Ribble Valley Planning Department,  
Council Offices,  
Church Walk,  
Clitheroe,  
BB7 2RA.

27th February 2024.

Re: Mr and Mrs Stummer, Appn. 3/2002/0841.

Title: Site Plan & Viewpoints

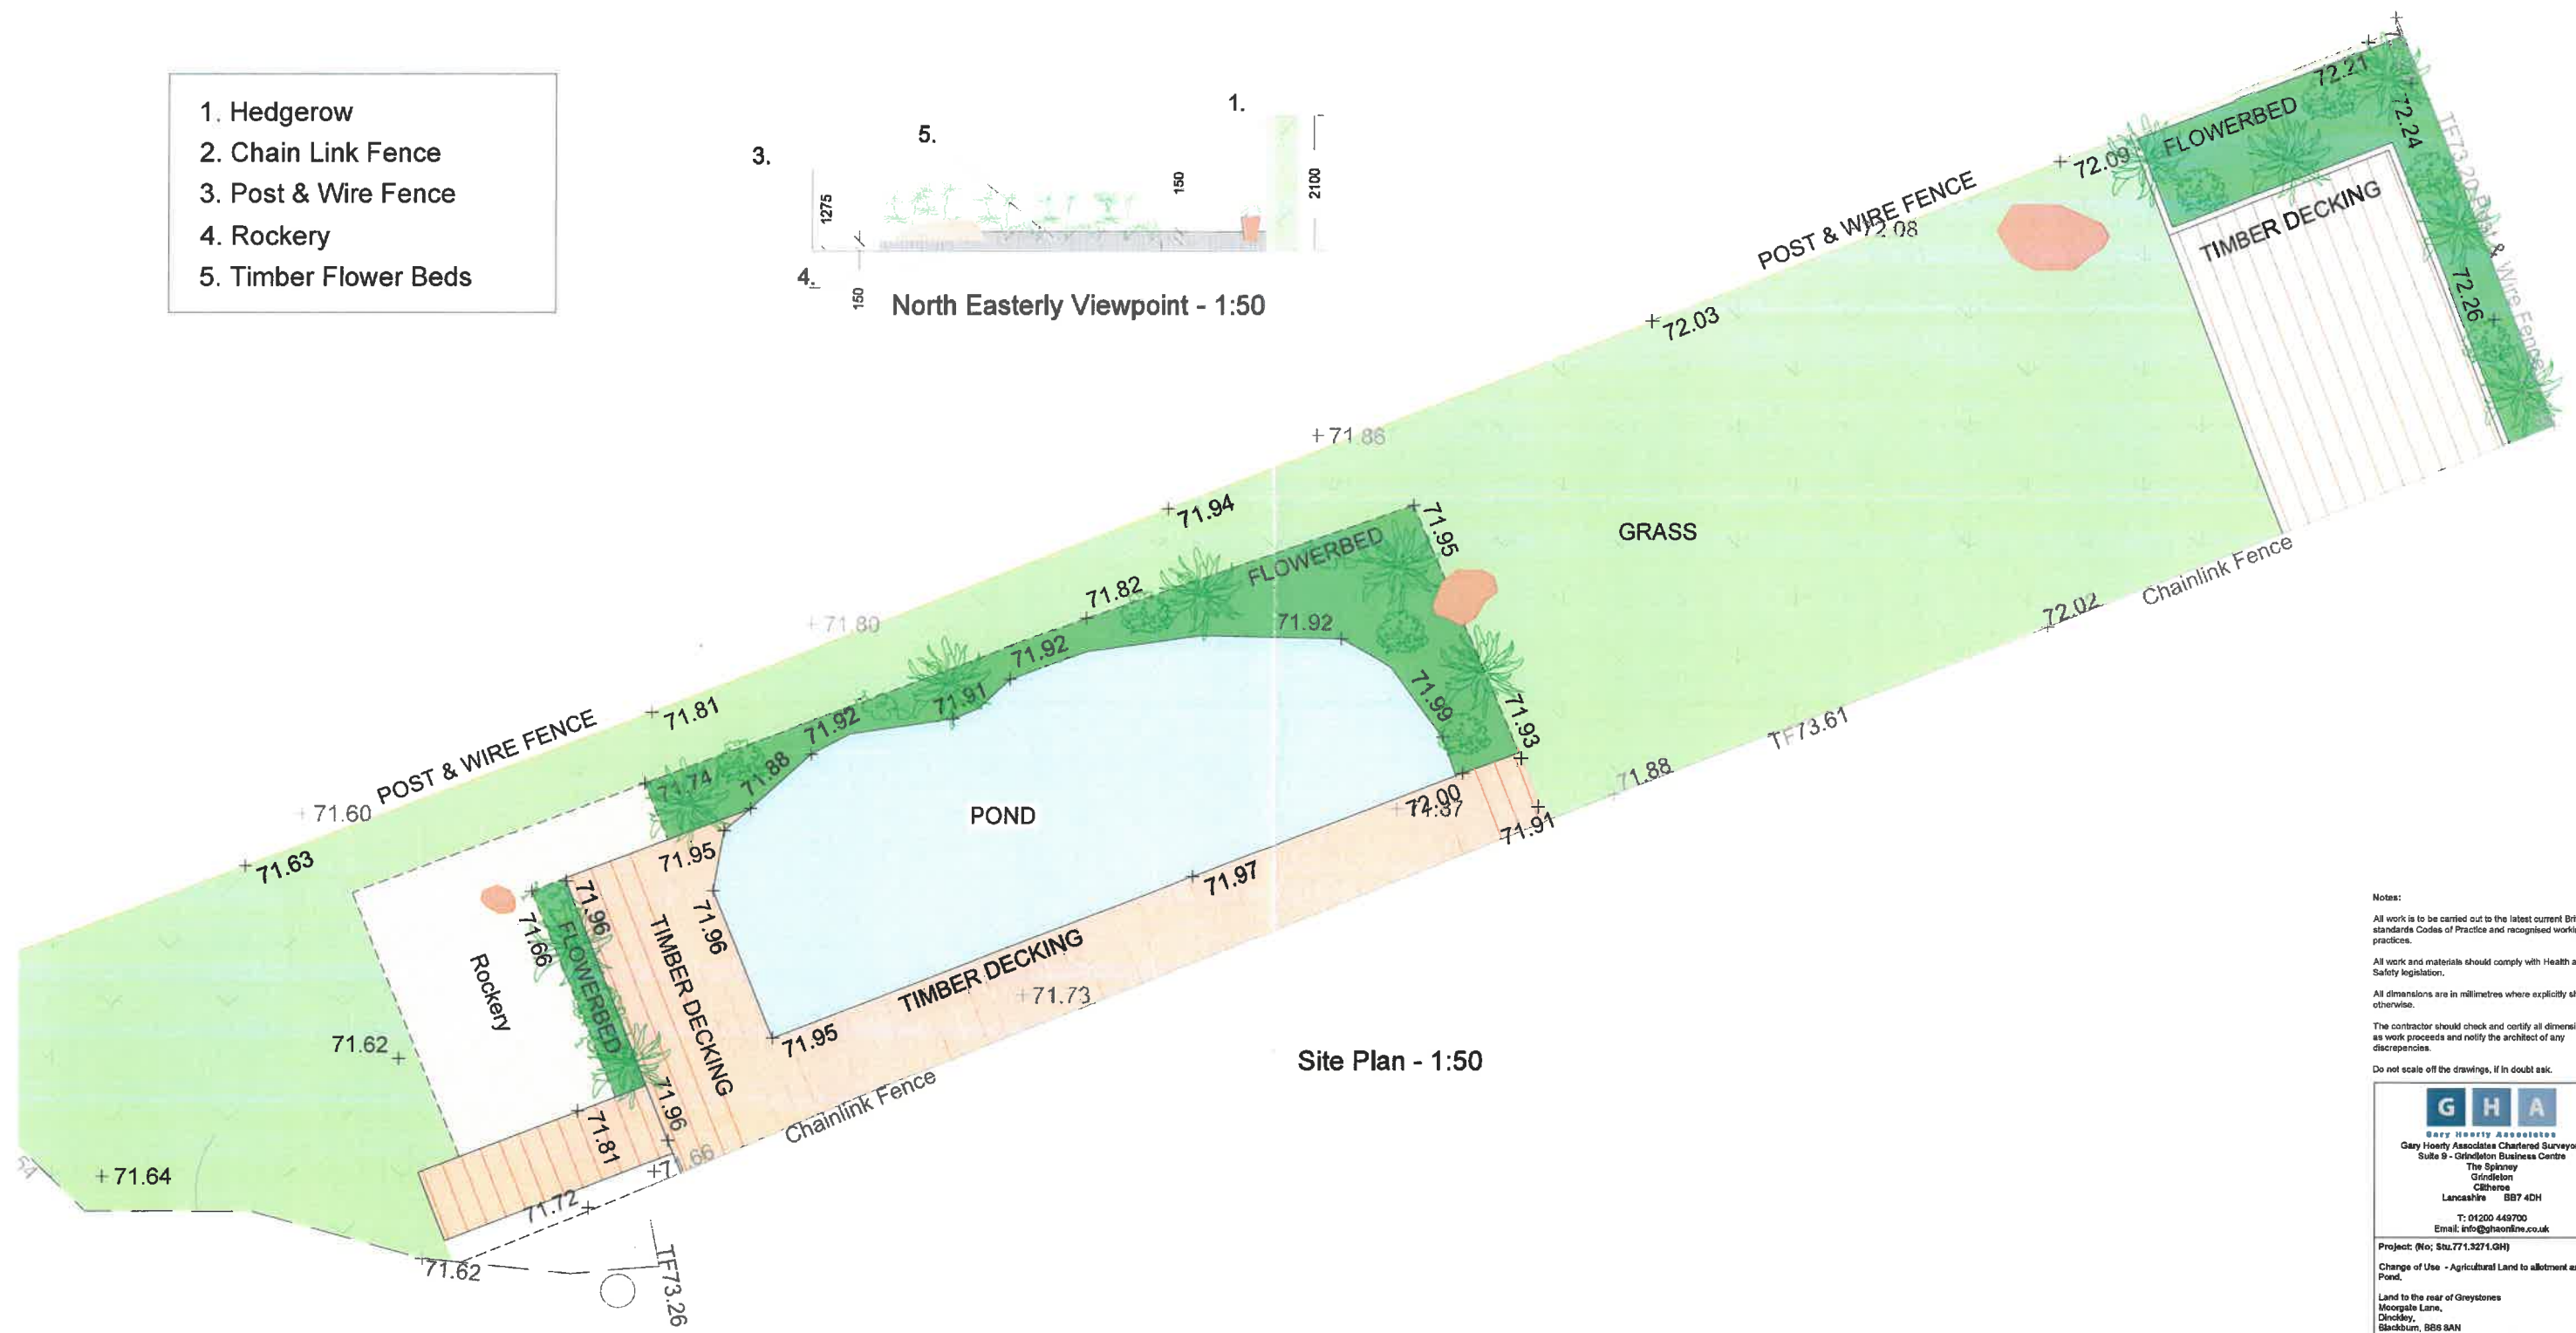
The "site plan and view points" submitted with the application demonstrates that it is currently impossible for the site to be described and used as an allotment as approximately two thirds comprise a pond, (which constitutes unauthorised groundwork) decking, a rockery and mature shrub/flower beds. All this results in a formally laid out ornamental, residential garden which has been constructed, without permission, purely for leisure purposes on a plot of land that was originally agricultural meadow land in contravention of the planning rules and policies and constitutes urbanisation of the countryside. This plot immediately abuts two long standing, substantial, detached country properties and is an invasion of their privacy.
